Recommendation Report for Planning Permission for Works or Extension to a Dwelling

REF NO: A/85/22/HH

LOCATION: Cranford
Ham Manor Way
Angmering
BN16 4JQ

PROPOSAL: Hip to gable loft conversion with dormer to rear and conversion of garage to habitable use.

ARW Design	DRAWING TITLE: FIRST FLOOR PLANS PROJECT: LOFT CONVERSION WITH HIP TO GABLE ENDS & DORMER TO REAR ELEVATION & GARAGE CONVERSION	LOCATION: CRANFORD, HAM MANOR WAY, EAST PRESTON CLIENT: N. PEARCE	SCALE: AS NOTED @ paper size A3 DATE: MARCH 2022	DRAWN: ARW	DRAWING NO: 6051/2 REVISION:

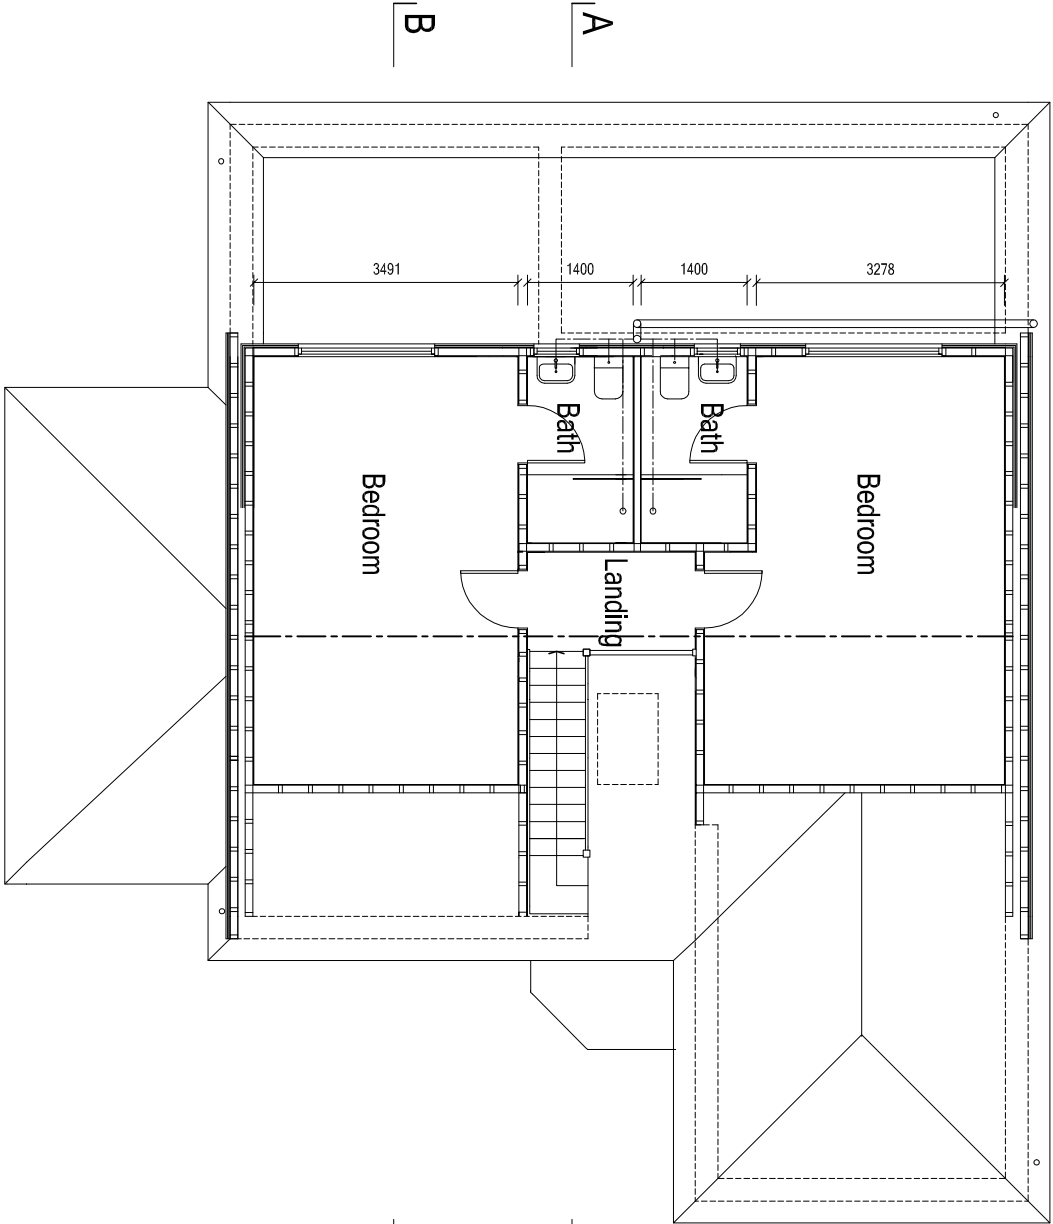
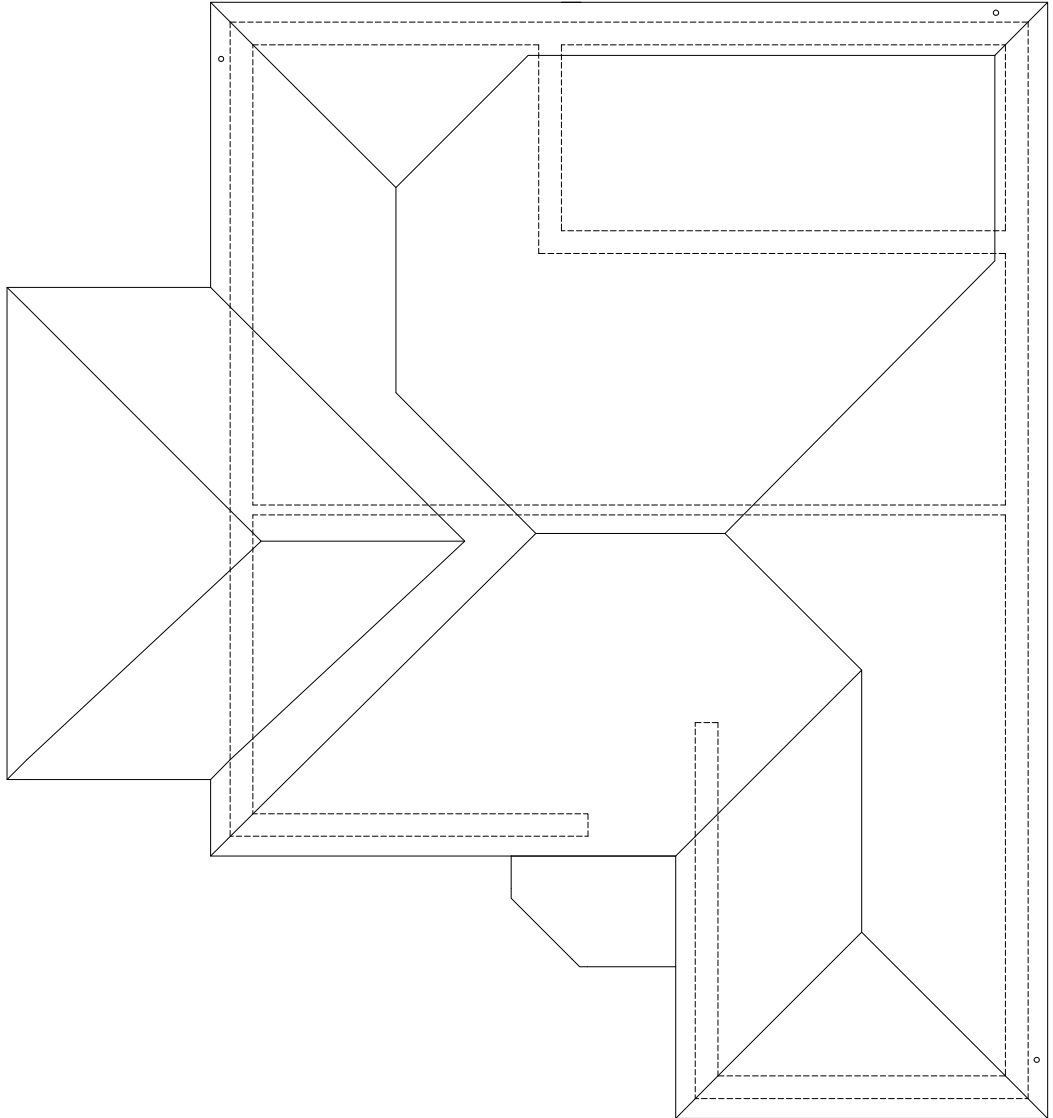
Regarding a loss of privacy, all proposed first floor fenestration will face towards the rear amenity space, which backs onto golf greens and does not result in any loss of privacy.

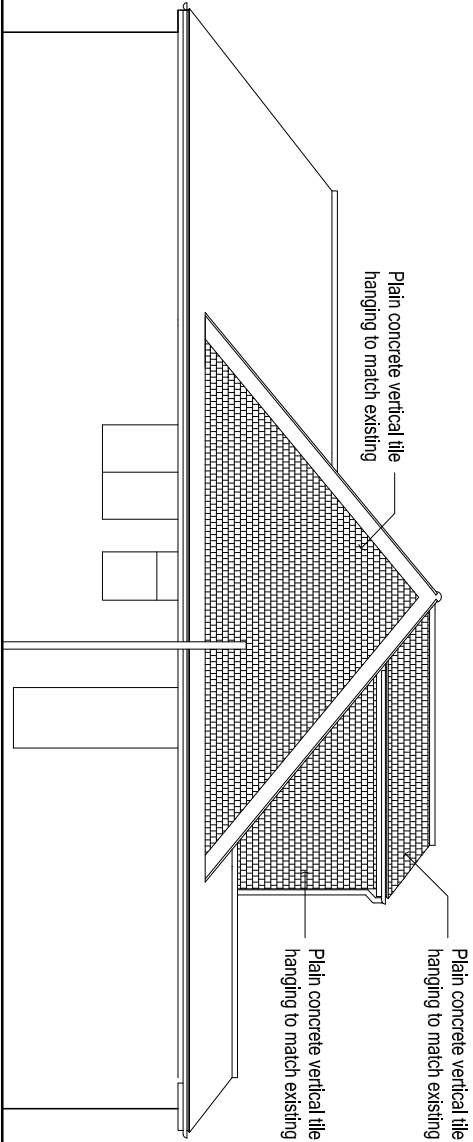
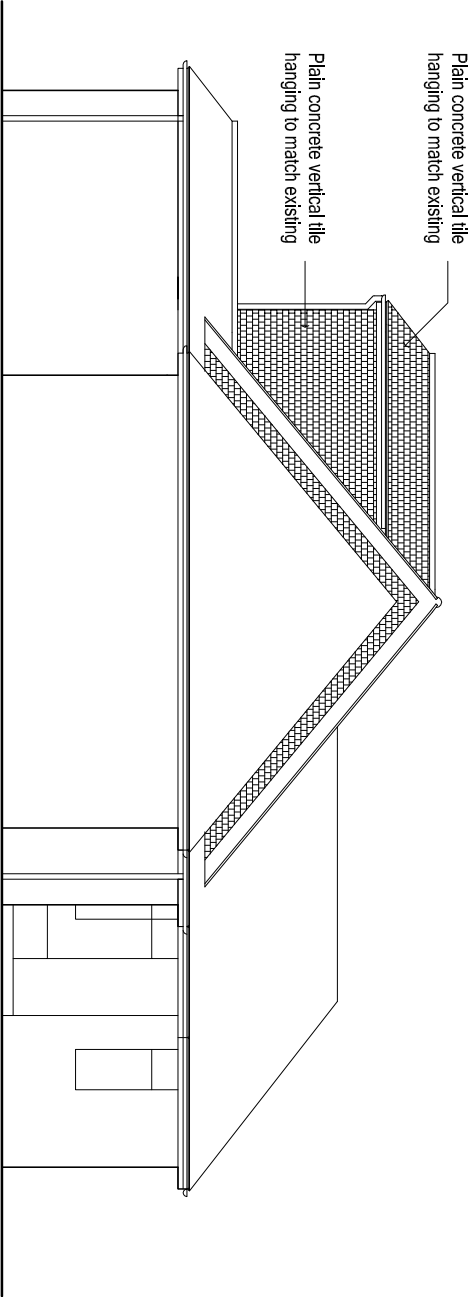
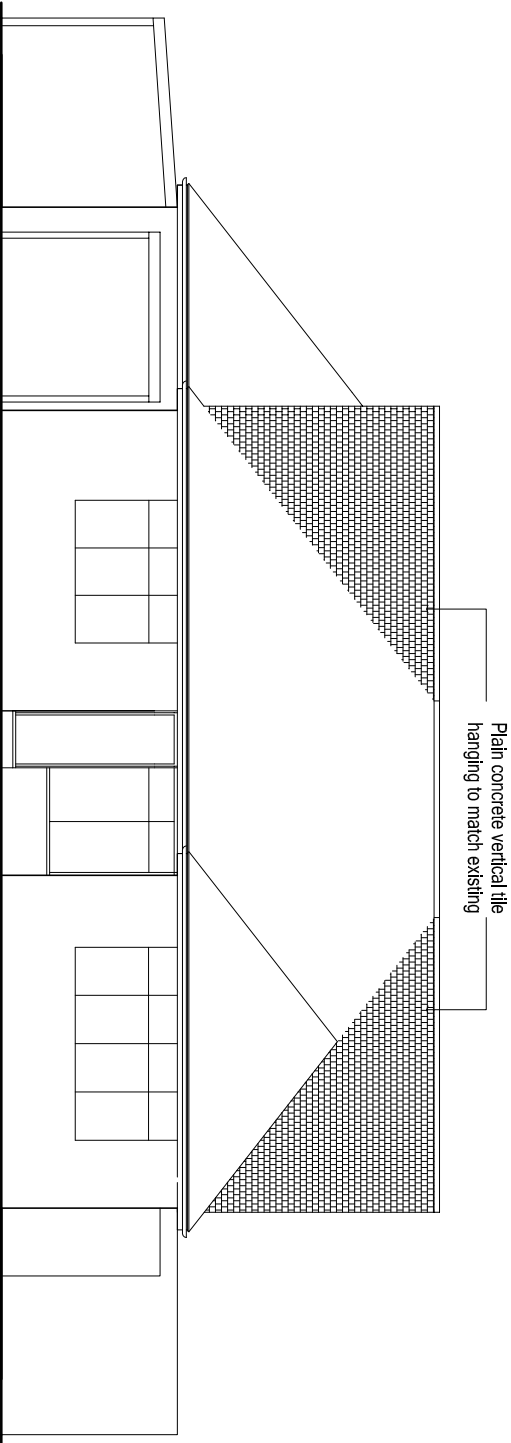
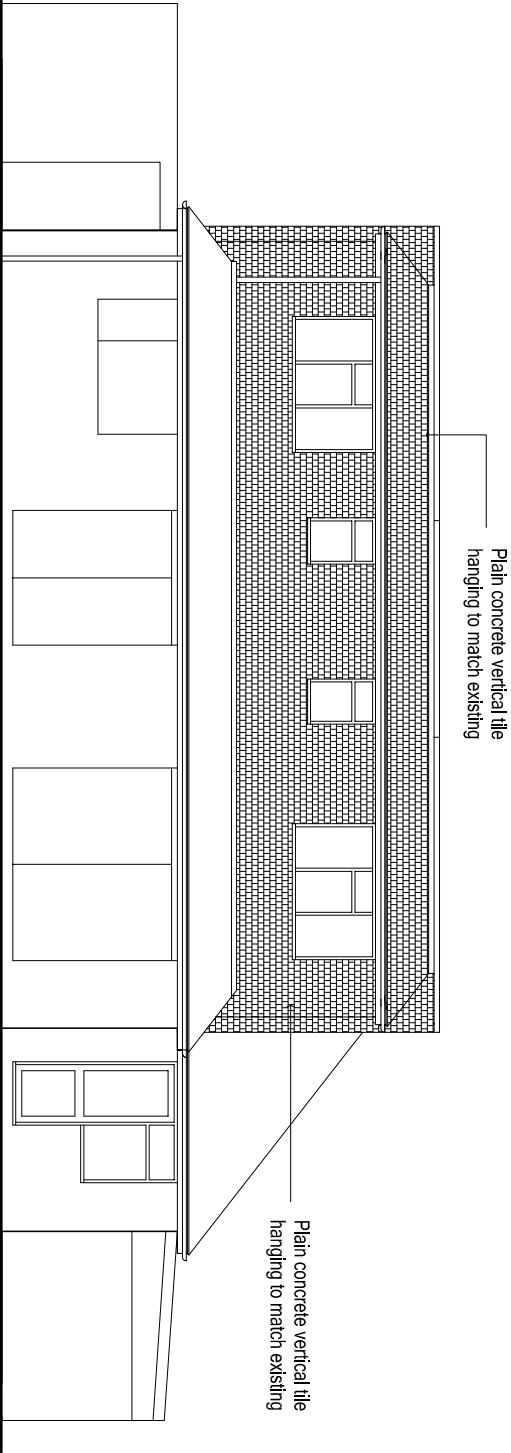
The host dwelling currently consists of a roof configuration which is hipped. It is proposed to extend the main bulk of the roof horizontally outwards to form a roof with gable-ends to each of the north-easterly and south-westerly elevations. This will then allow a box dormer to extend the full width of the roof to the rear.

The hip to gable alterations will be visible from the street. However, given their position behind a smaller front protrusion and by reason that the current design features of the host dwelling i.e., eaves and ridge height will be retained and that they are acceptable in that they are subservient and visually integrated with the host dwelling, they will not have a significant harmful impact on the character of the area generally.

The rear box dormer, by reason that it will appear well integrated with the host dwelling and as it is a subservient form of development, complies with policy.

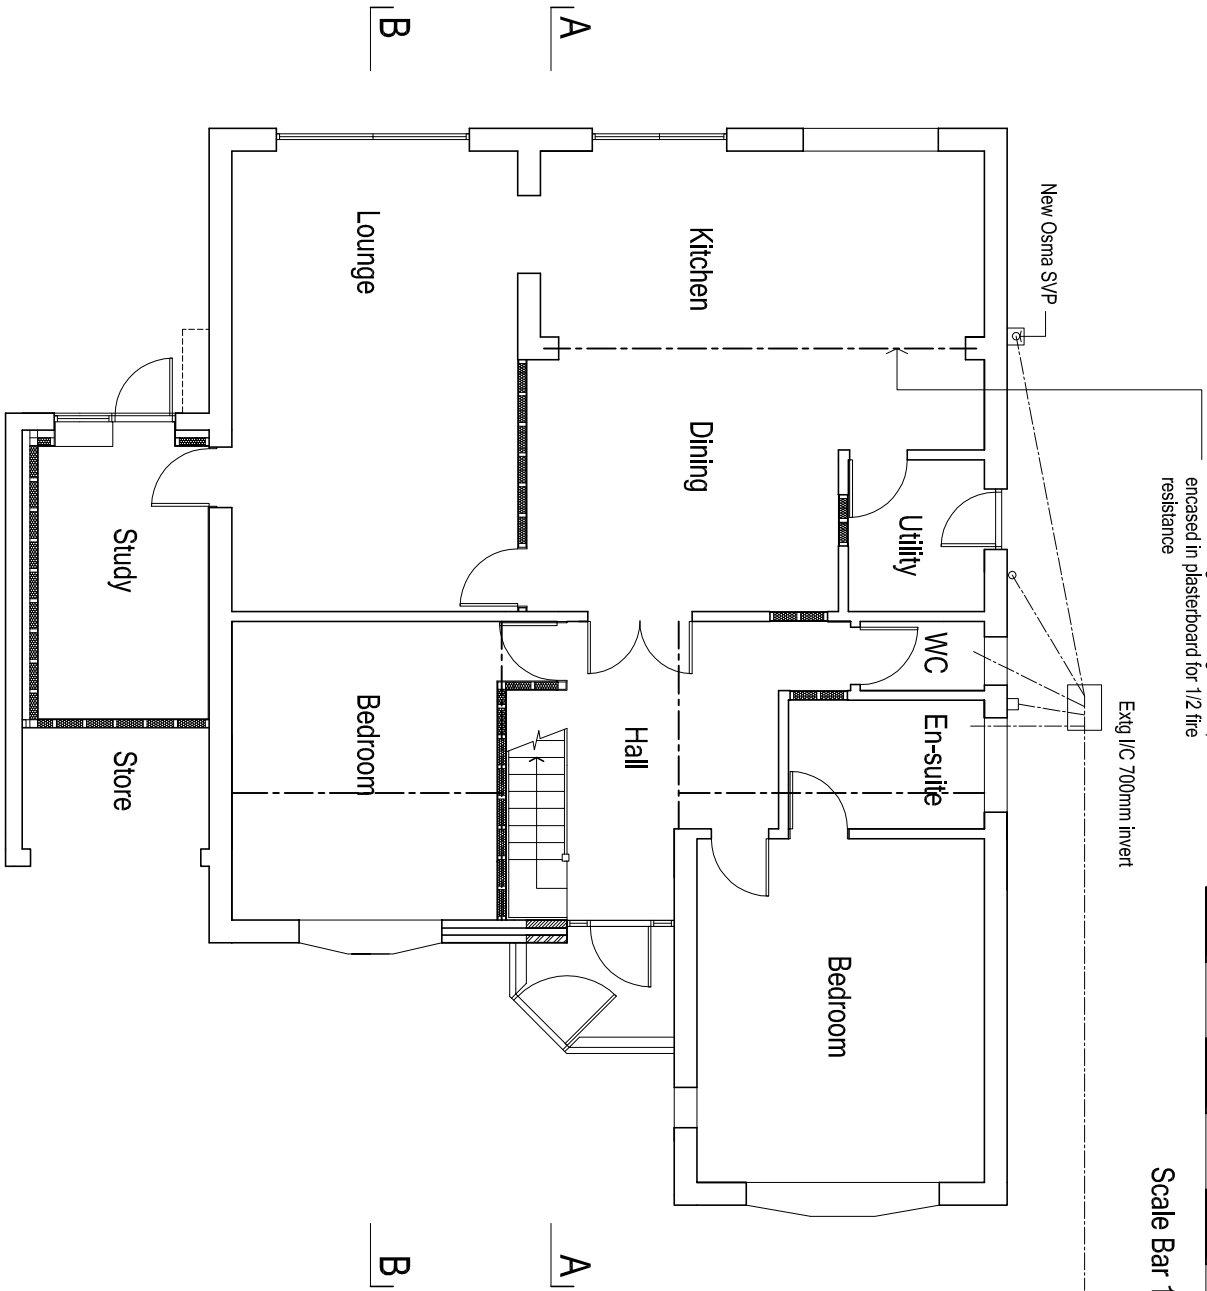
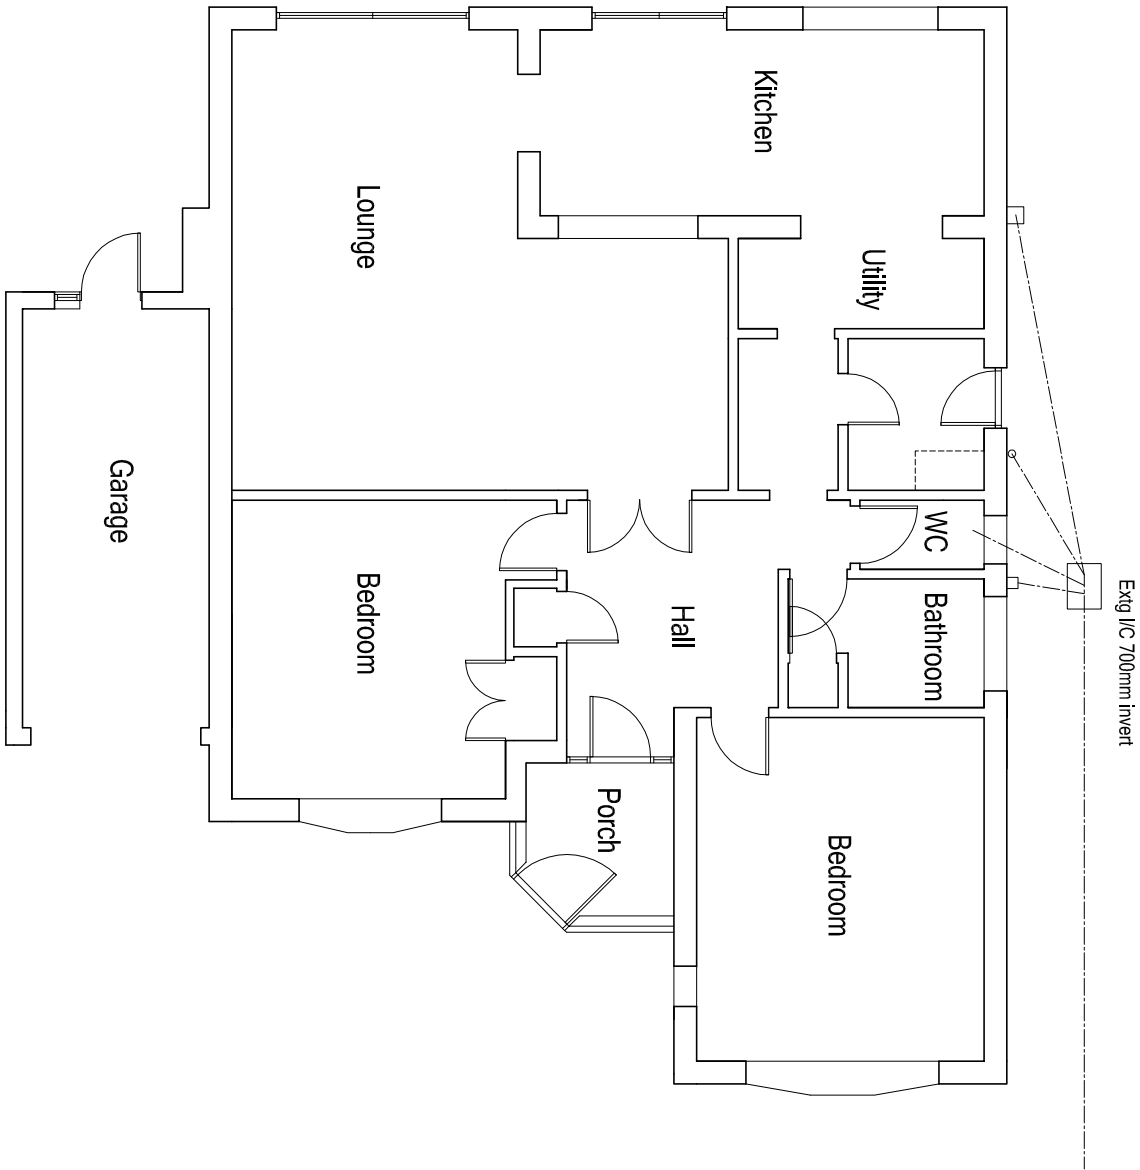
The proposed garage extension is not visible externally, as such has no visual impact on the dwelling or surrounding area.
